**WELWYN HATFIELD BOROUGH COUNCIL
EXECUTIVE DIRECTOR - PLANNING, PUBLIC PROTECTION AND GOVERNANCE**

Application No: 6/2022/2530/HOUSE
Location: The Lodge 2 Northaw Place Coopers Lane Northaw Potters Bar EN6 4NQ
Proposal: Erection of a part-single, part-two storey side extension and part subterranean extension
Officer: Ms Kirsty Shirley

Recommendation: Refused

Title:
**Basement and Ground Floor Plan
as Proposed**

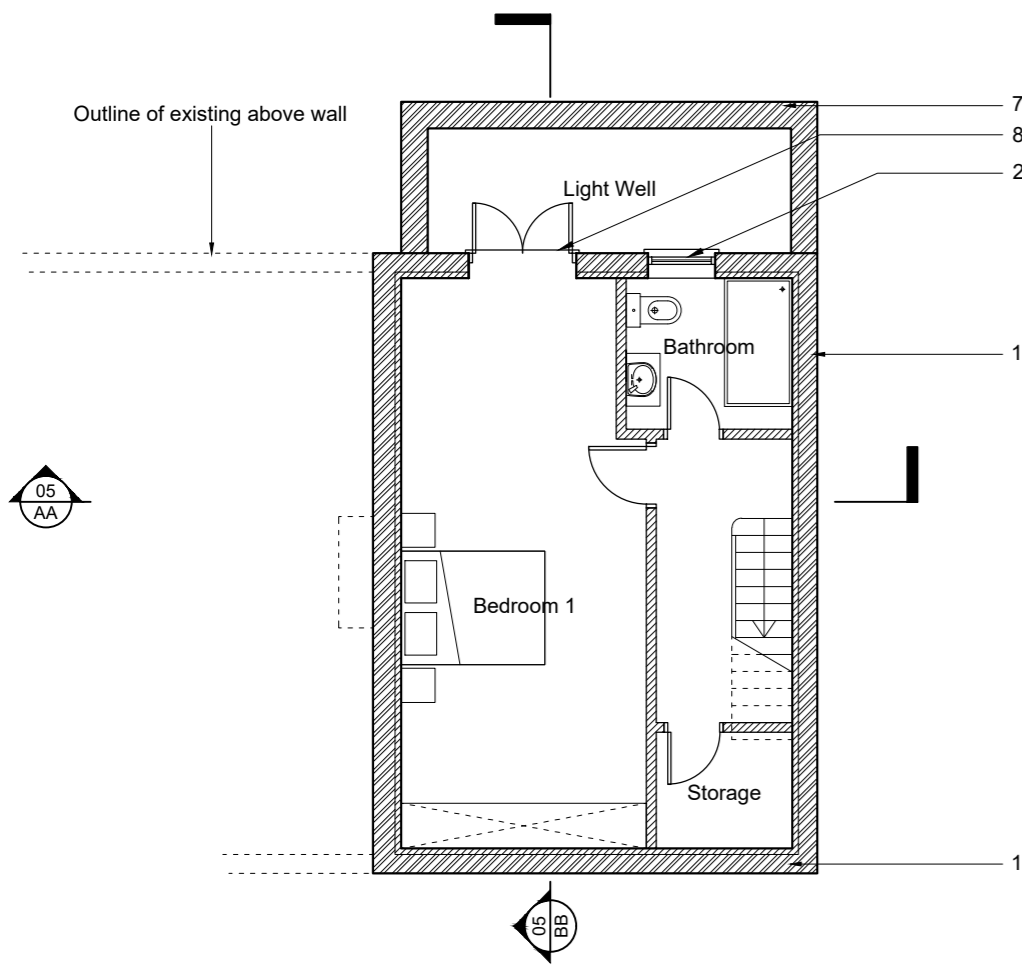
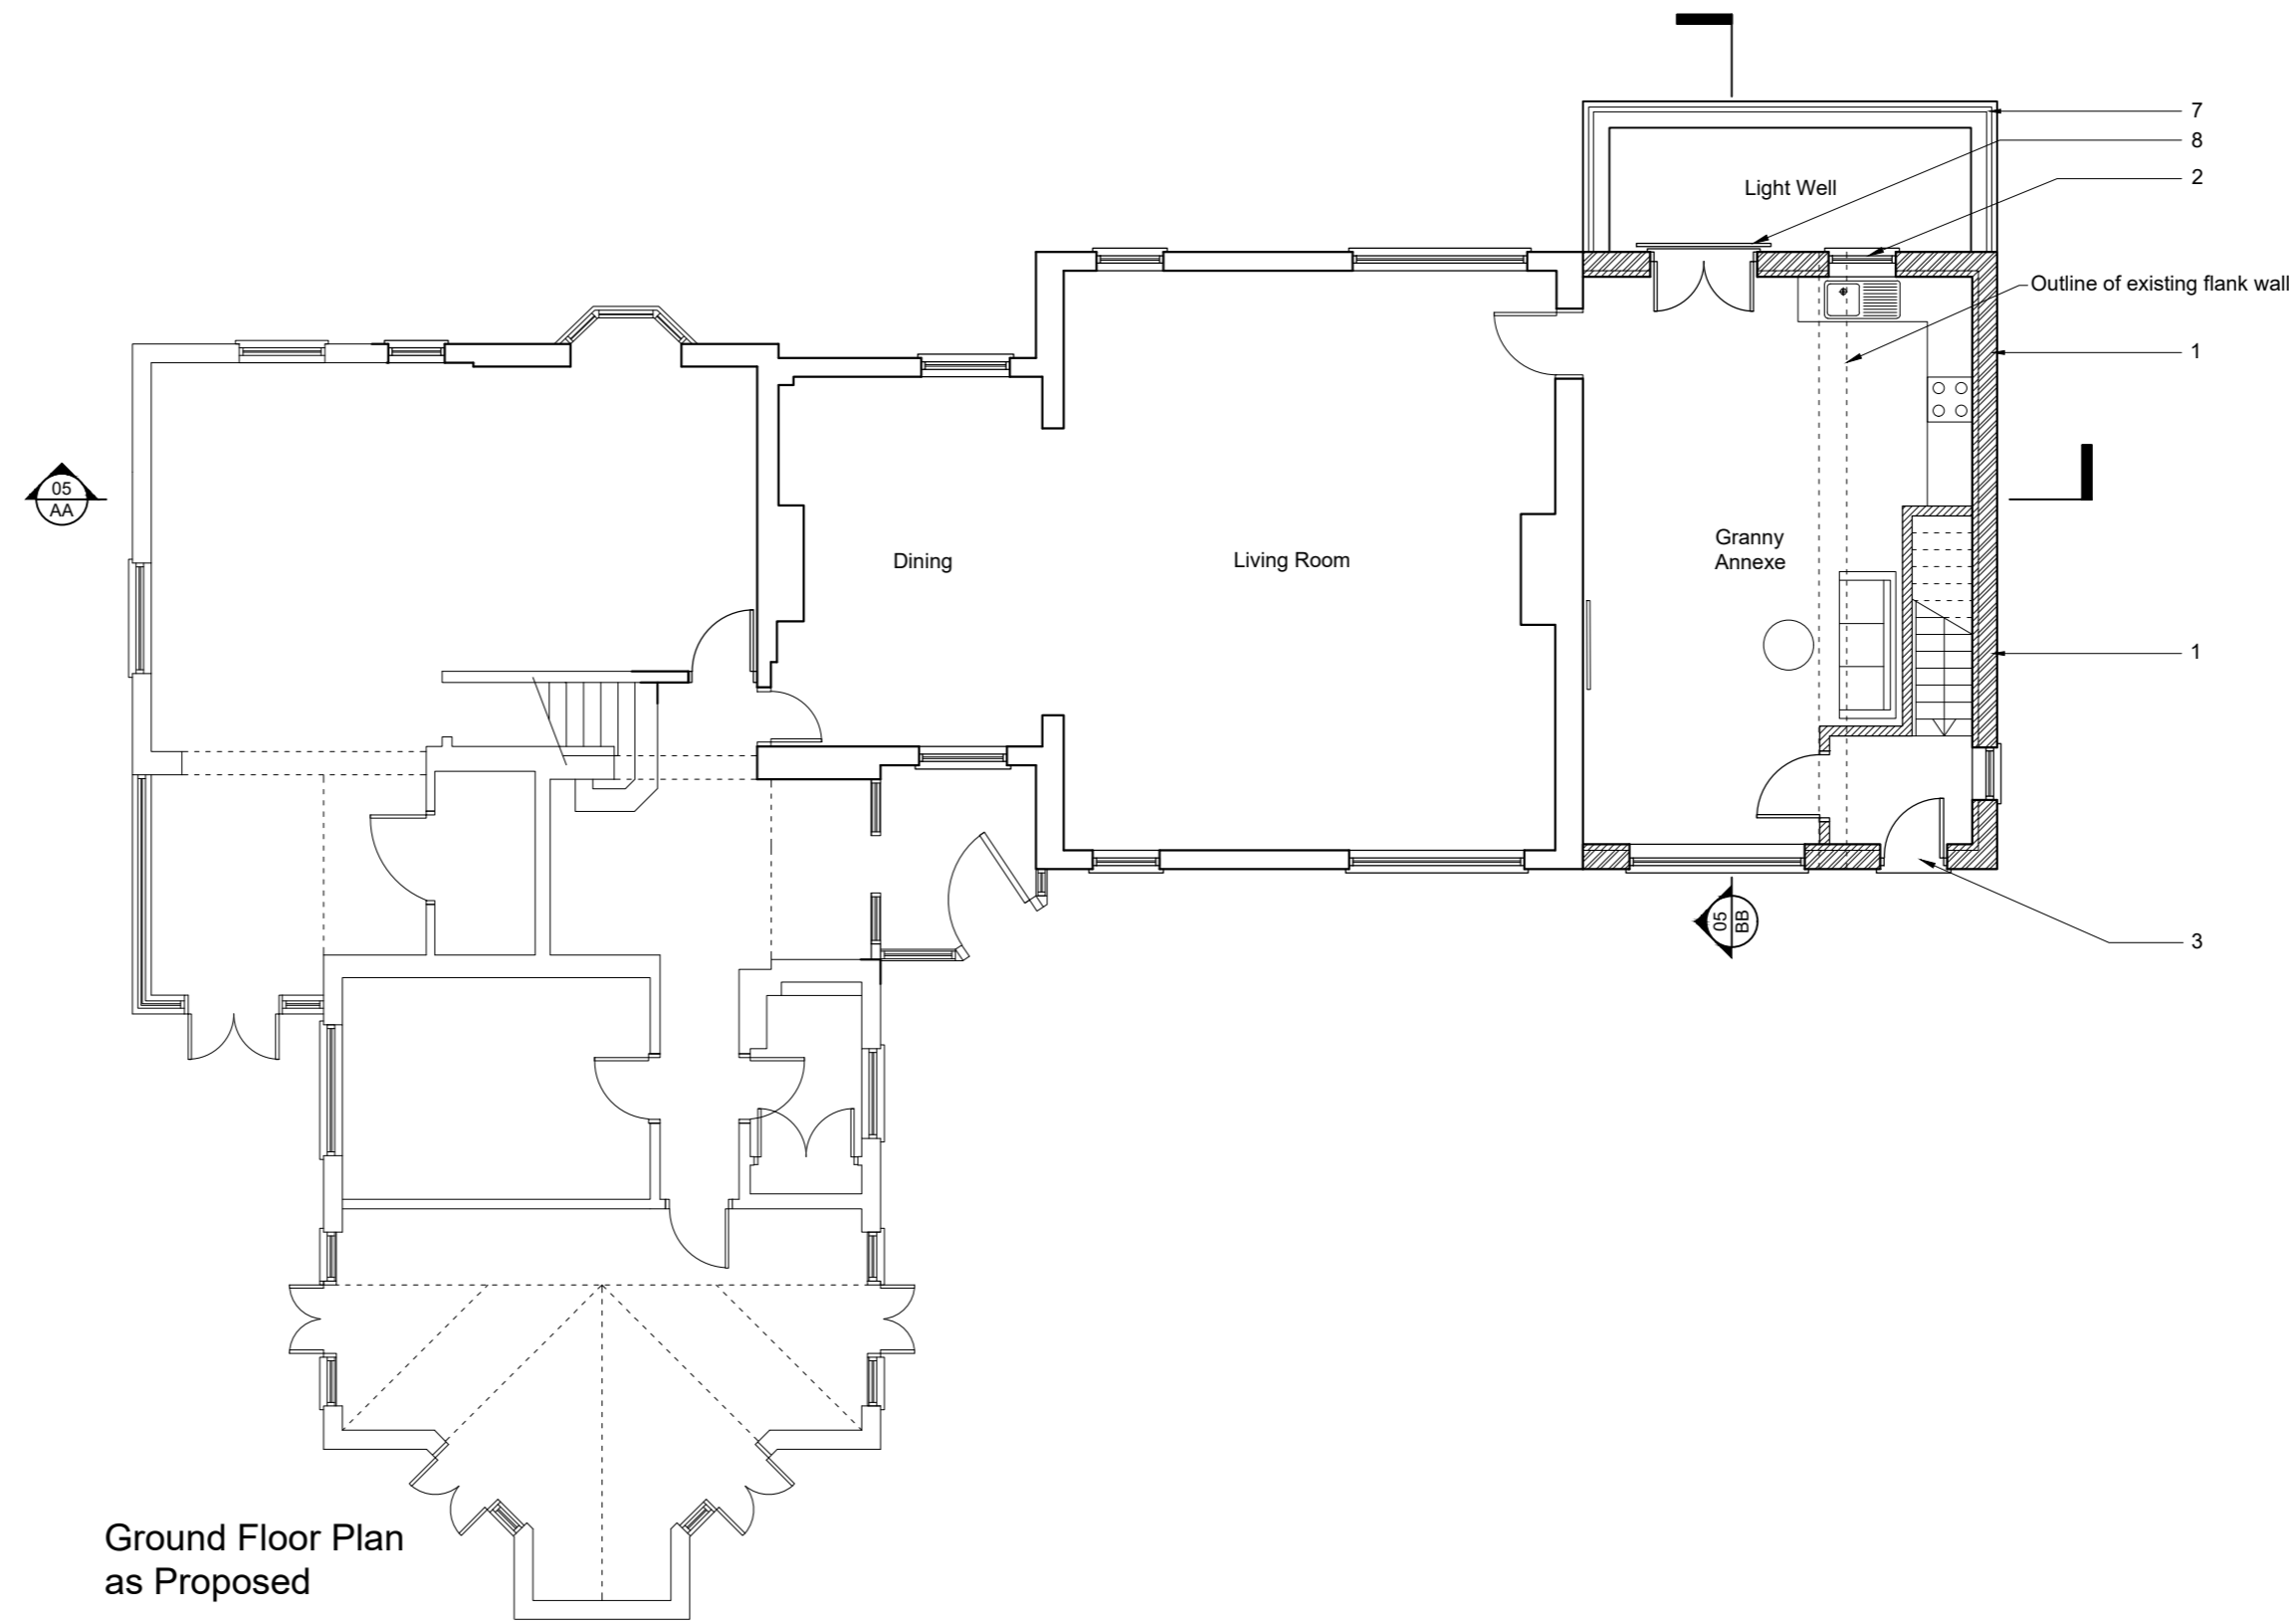
The application site has been extended and altered over many years. The Local Planning Authority considers that the floor space of the original property was approximately 198m². Additions to the property have resulted in a considerable increase in the overall floorspace of the dwelling so that it is now in excess of 300m², resulting in a floor area that has been increased by over 65% when compared to that of the original building. This application is for the erection of a part single, part two storey side extension with subterranean development. Any additional increase in floor space on the site will increase

<p>this percentage further. The proposed development would result in an increase in footprint at ground and first floor level, as well as an increase in floor area at subterranean, ground and first floor level. The dwelling as existing already represents a disproportionate increase compared to the original dwelling and as such the proposed development would exacerbate the existing disproportion.</p> <p>In terms of a qualitative assessment, the first-floor extension has been reduced in size compared to previously refused application 6/2022/1508/HOUSE. However, the first-floor extension proposed in this current application still adds bulk and massing to the application dwelling. This application also includes subterranean development, which would add further bulk and massing to the dwelling.</p> <p>It is therefore considered that the proposed extension would be substantial in comparison to the original building as to be disproportionate. The proposal therefore represents inappropriate development within the Green Belt. The NPPF confirms that inappropriate development is by definition harmful to the Green Belt.</p> <p><i>Openness</i></p> <p>The NPPF identifies the essential characteristics of Green Belts are their openness and their permanence. There is no definition of openness in the NPPF but, in the context of the Green Belt, it is generally held to refer to freedom from, or the absence of, development. However, assessing the impact of a proposal on the openness of the Green Belt requires a judgment based on the circumstances of the case.</p> <p>Openness is capable of having both spatial and visual aspects - in other words, the visual impact of the proposal may be relevant. The specific characteristics of the proposal and its setting are also relevant in this case when making an assessment.</p> <p>The application dwelling is setback from the Coopers Lane and is mostly screened by fencing and vegetation. The subterranean development would be mostly concealed from view due to its positioning below the application dwelling. However, a lightwell and a balustrade surrounding the lightwell would indicate the presence of subterranean development. The intensification of such paraphernalia would diminish the openness of the site.</p> <p>Furthermore, while the first-floor development has been reduced in size compared to previously refused application 6/2022/1508/HOUSE, the development would still introduce built form in an area which currently provides open space.</p> <p>Consequently, the development would result in a material loss of Green Belt openness in spatial terms and the proposal therefore fails to overcome refusal reason 1 of 6/2022/1508/HOUSE.</p>
